Ribble Valley Borough Council
Council Offices
Church Walk,
Clitheroe
Lancashire
BB7 2RA

Phone: 0300 123 6780
Email: developeras@lancashire.gov.uk
Your ref: 3/2025/0999
Our ref: 3/2026/0369/HDC/KW
Date: 24 July 2026

Location: 69 King Street Whalley BB7 9SW

Proposal: Proposed part change of use from retail shop to bakery with staff accommodation at first floor (sui generis). Demolition of existing single-storey rear extension and construction of new extension to rear. Installation of retractable frontage canopy, ramp/steps and handrail. Installation of replacement windows, service yard security gates and ancillary external seating.

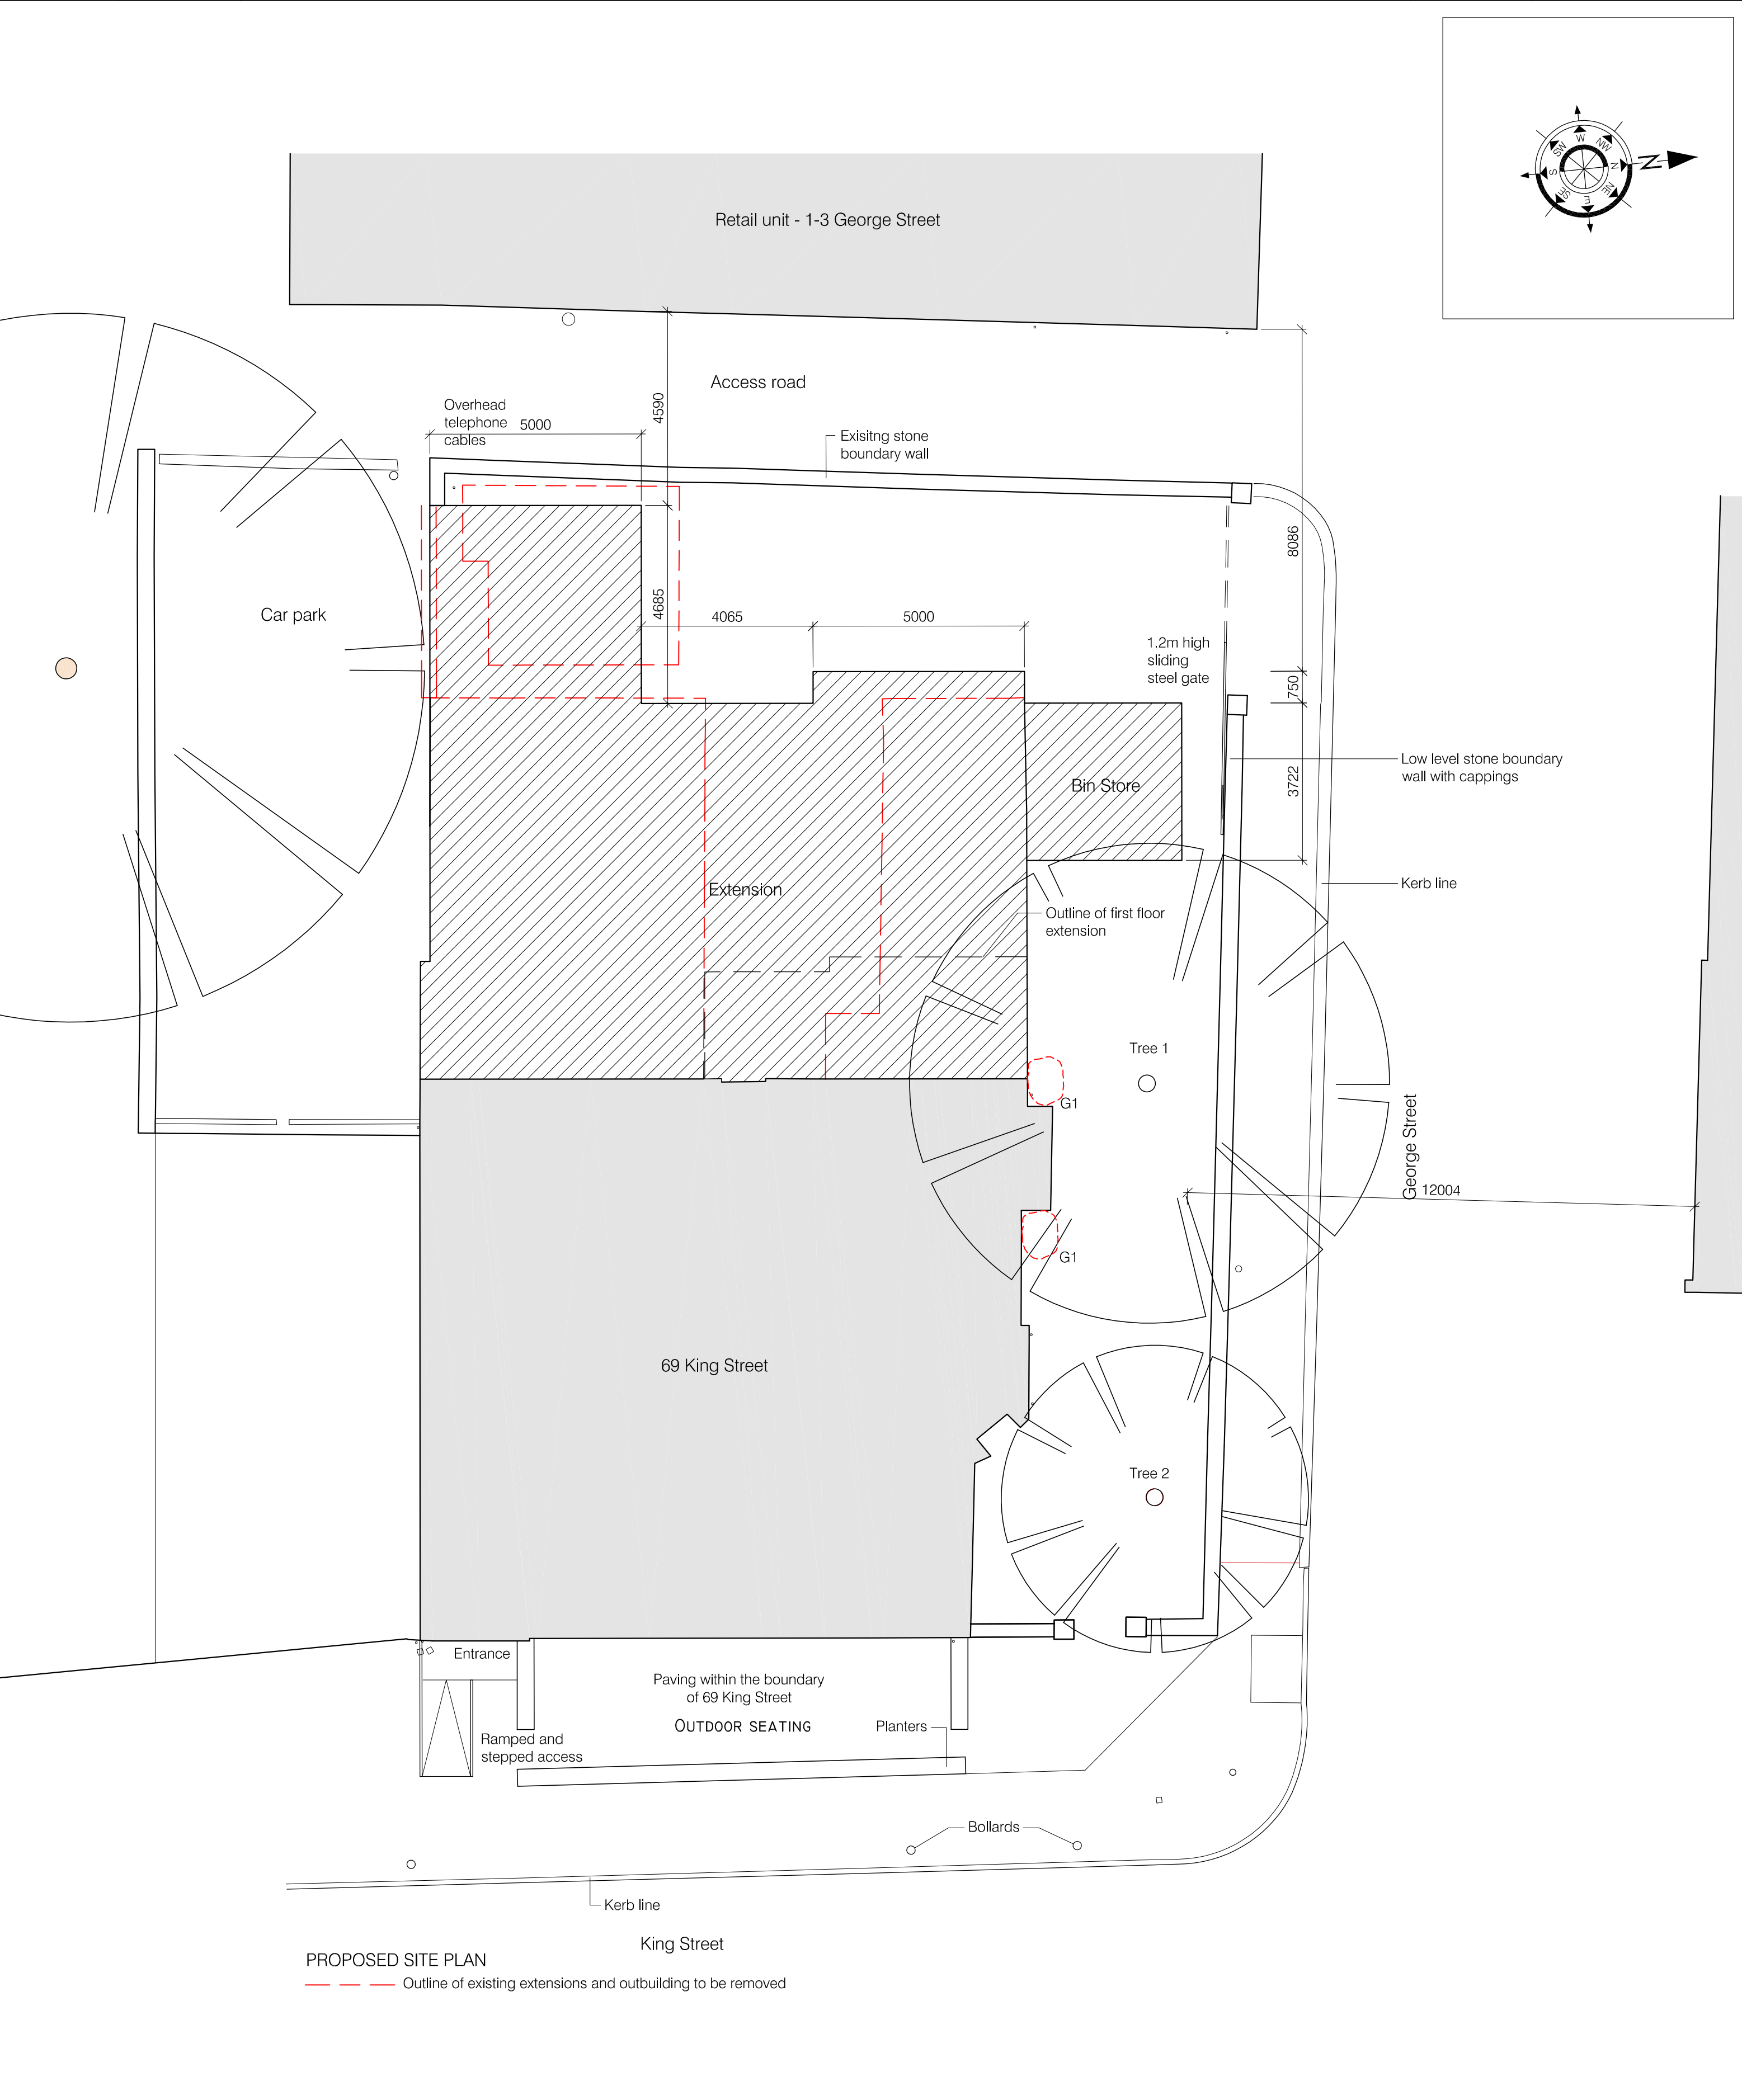
It is understood that the applicant intends to retain the existing vehicle access to provide access to a service area within the site. A 1.2m sliding gate is proposed; however, this has not been set back from the highway edge and, given its height, may obstruct visibility. Further information is required to assess the frequency of use of the access, which will assist in determining the acceptability of the design.

In line with the parking standards as set out within Appendix 2 of the Joint Lancashire Structure Plan, a six bedroom property should be provided with at least 3 off street parking spaces. When considering the available space to create parking within the proposed site plan, the LHA is of the opinion that, as currently presented, there will be an under provision of parking within the site.

The LHA also has concerns regarding servicing arrangements for the site. The proposal includes a service yard accessed from George Street. George Street accommodates a mix of commercial activity, residential access and on-street parking demand as such, there is a high volume of pedestrian movement fronting the proposed access to the servicing area. A bakery operation of this nature can reasonably be expected to generate regular deliveries. The current service yard arrangements do not include any turning provisions and as such the LHA expects a level of reversing movements into the site. No Servicing and Delivery Management Plan has been submitted and the LHA would request that further information is provided to consider if these arrangements are acceptable in terms of highway safety. Information should be provided detailing:

- If deliveries and servicing will be made via a third party or are operated and controlled by Northcote/the applicant.
- Delivery frequencies.
- Vehicle sizes.
- Delivery hours.
